Ribble Valley Borough Council
Council Offices
Church Walk,
Clitheroe
Lancashire
BB7 2RA

Phone: 0300 123 6780
Email: developeras@lancashire.gov.uk
Your ref: 3/2025/0861
Our ref: 3/2025/0861/HDC/KW
Date: 11 December 2025

Location: Burnhouse Farm Back Lane Slaidburn BB7 3EE
Proposal: Proposed construction of No.3 camping lodges and a utility hut including associated hardstanding and landscaping.
Grid Ref: 368160 452765

Proposed Site Plan
 Scale (1:500)

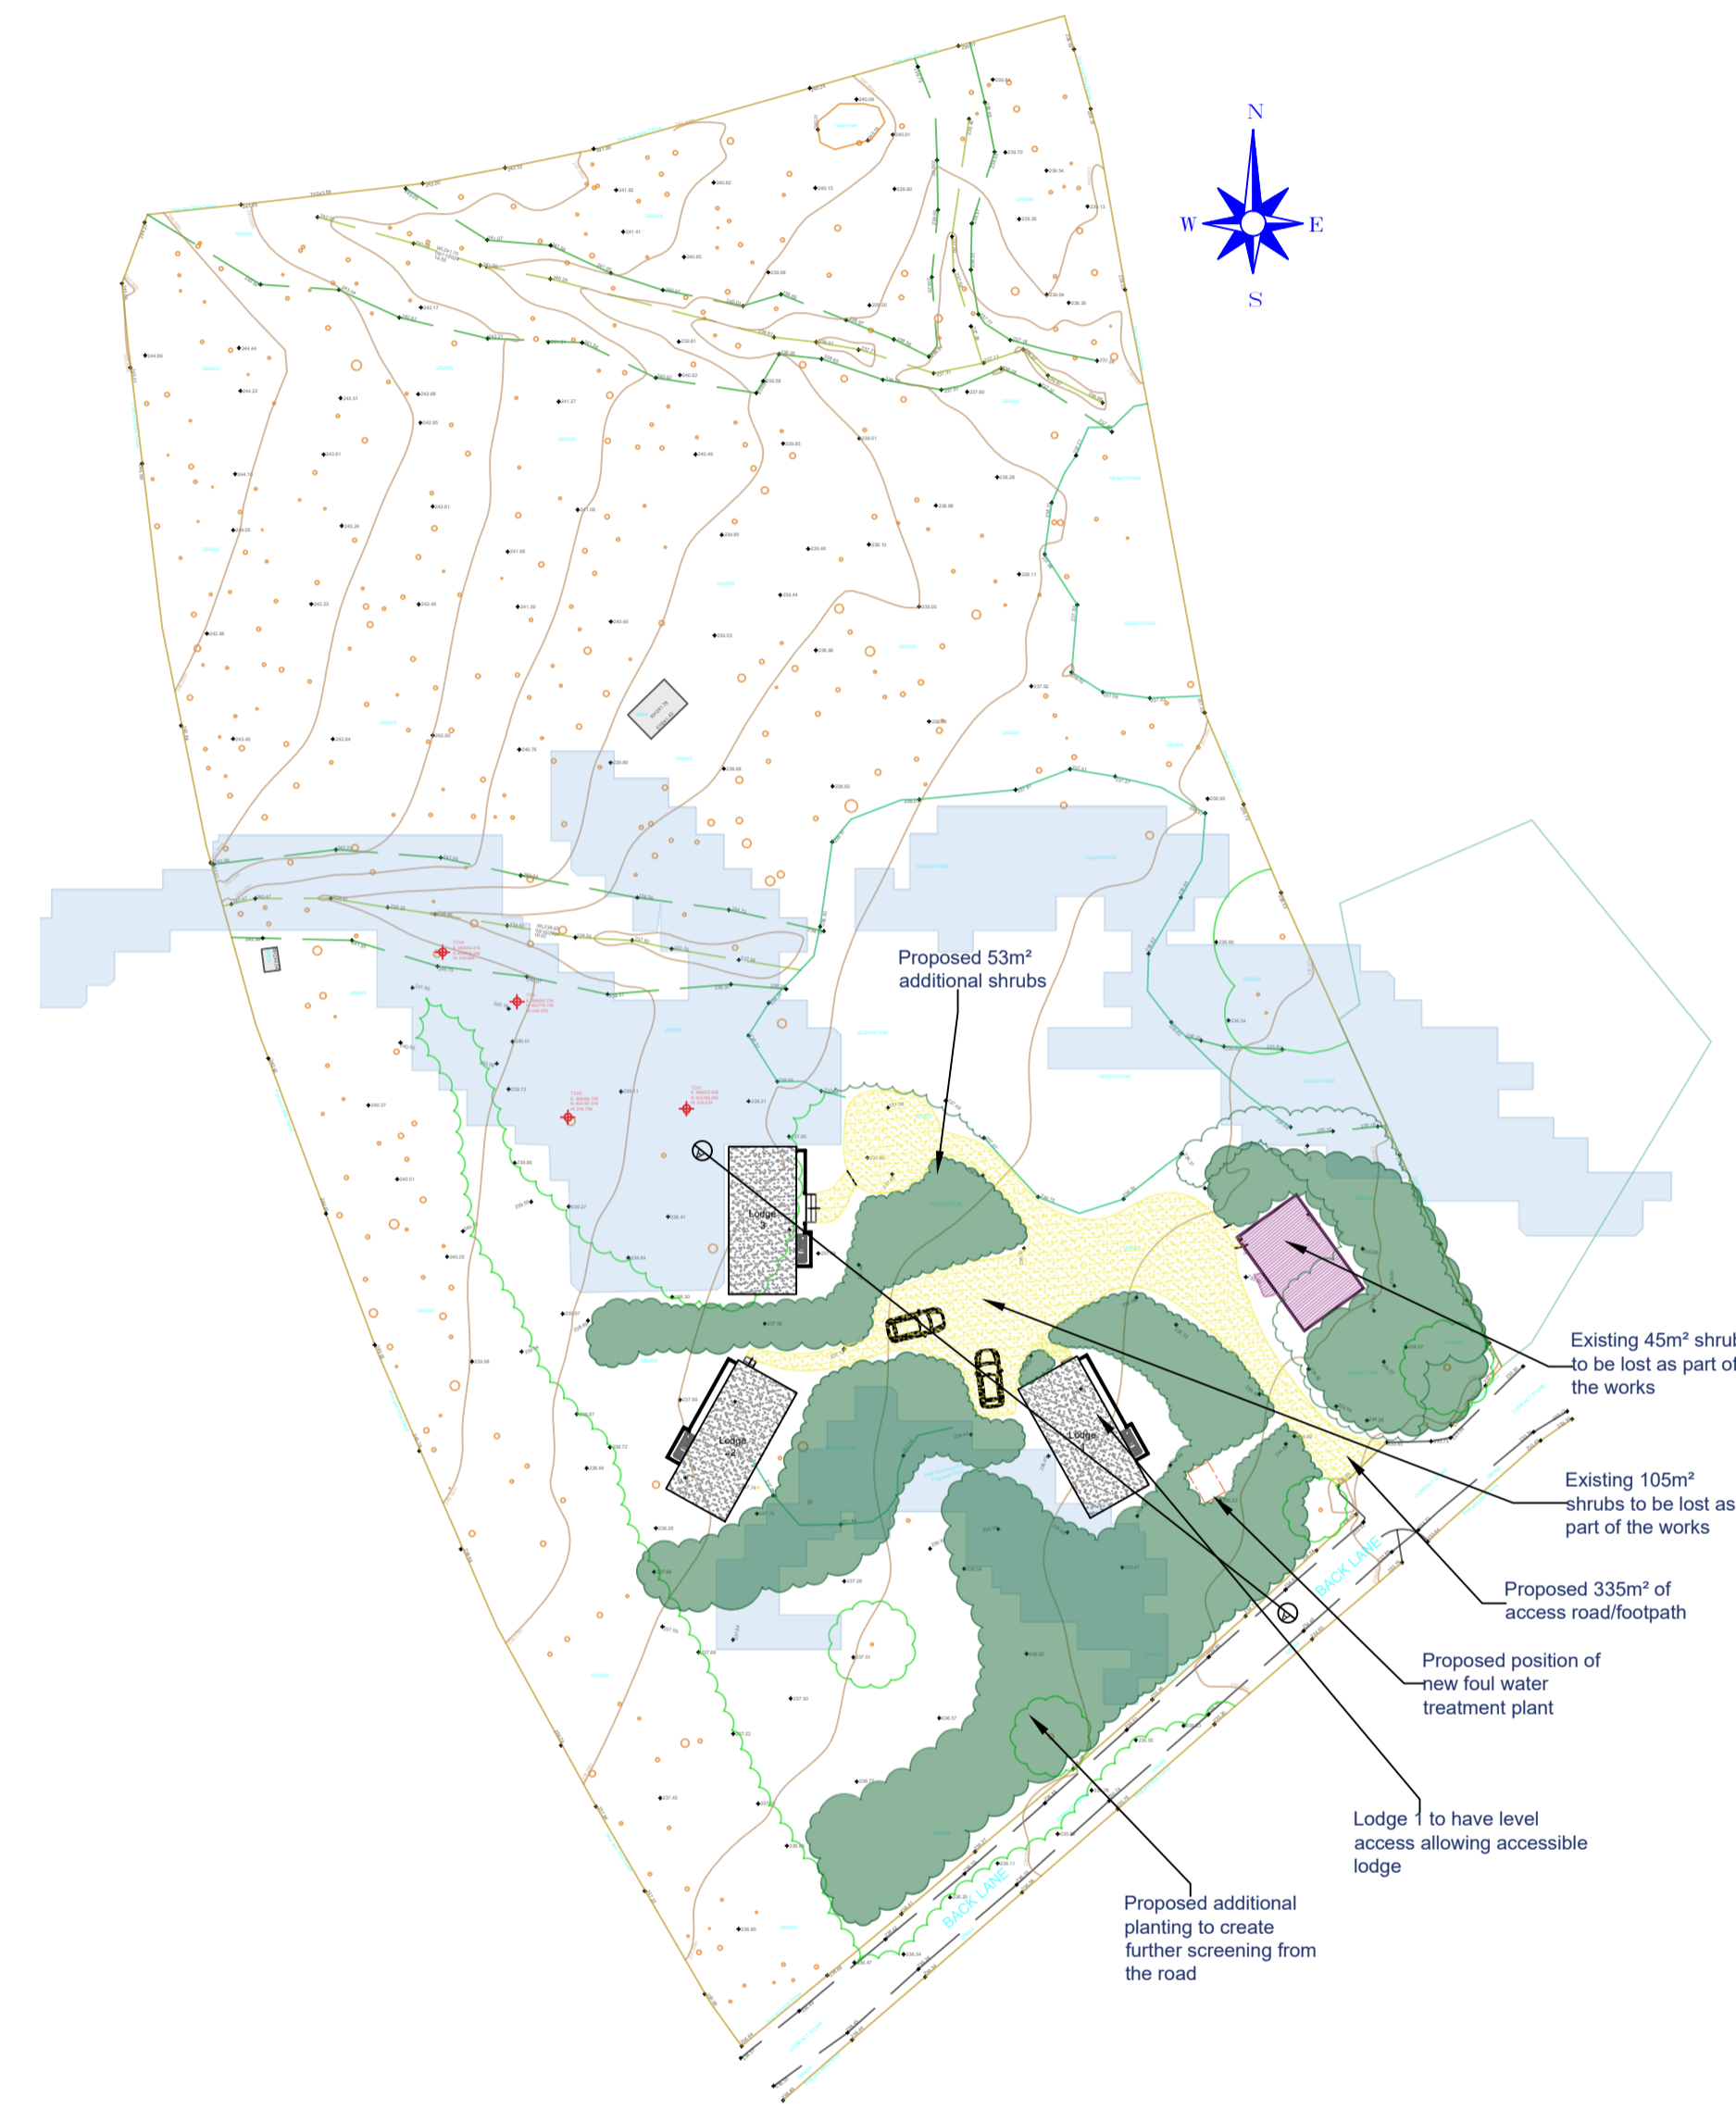
The LHA have reviewed the Proposed Site Plan, drawing C193-5 – 007 Revision E and are aware that the holidays pods are provided with one parking space each. The pods each provide one bedroom and as such the parking provisions are acceptable to the LHA. There is also room to turn within the site allowing for ingress and egress in a forward gear.

# Laundry & Bike Shed

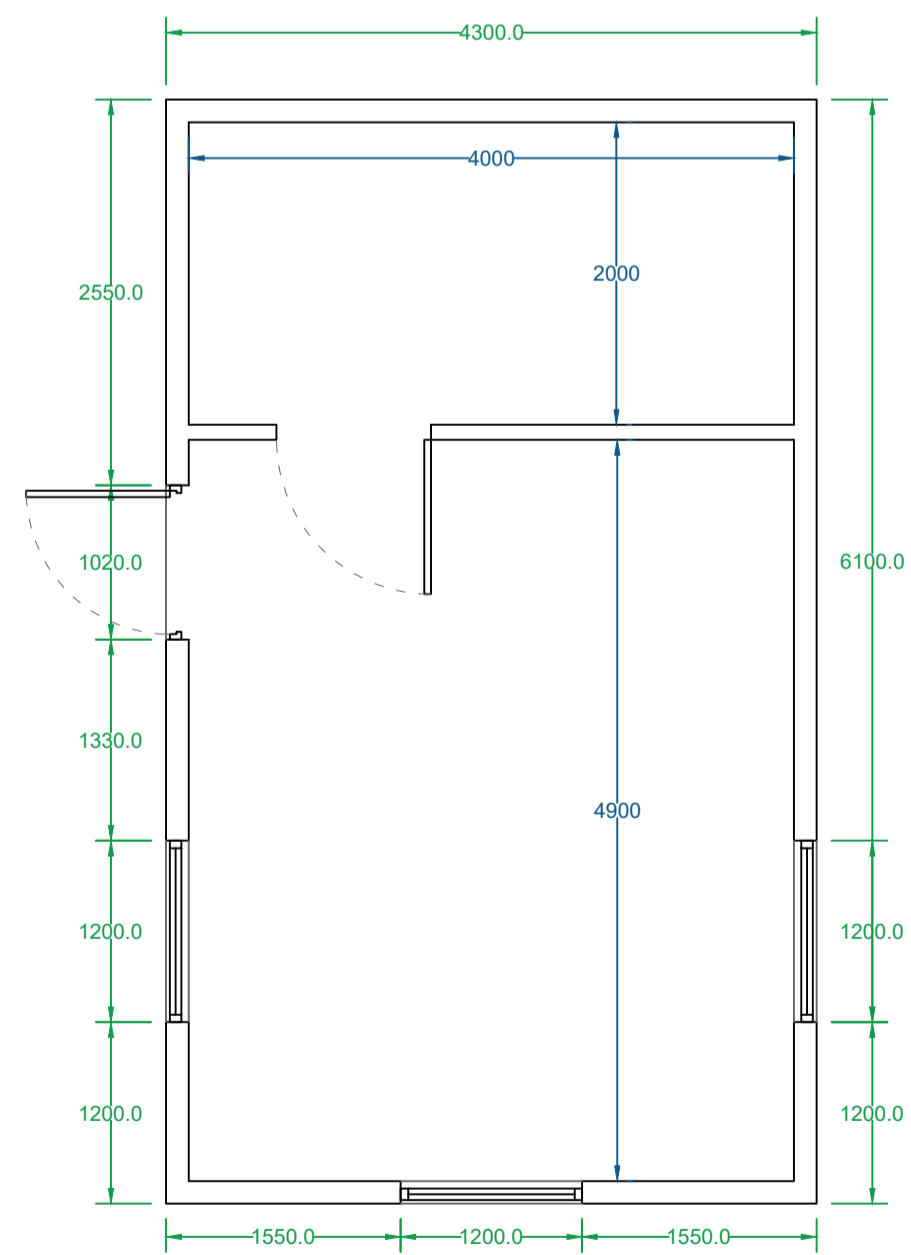
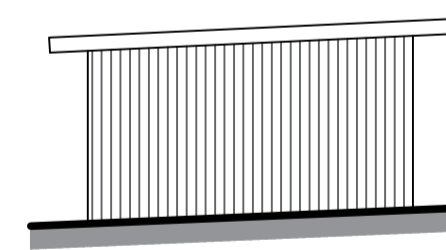
The site shall enhance its sustainable transport options to actively encourage and support sustainable transport use. The LHA notes that the development includes covered and secure cycle storage, as seen on drawing C193-5 – 008 Rev D, which will ensure adequate parking provisions and promote cycling as a sustainable mode of transport.
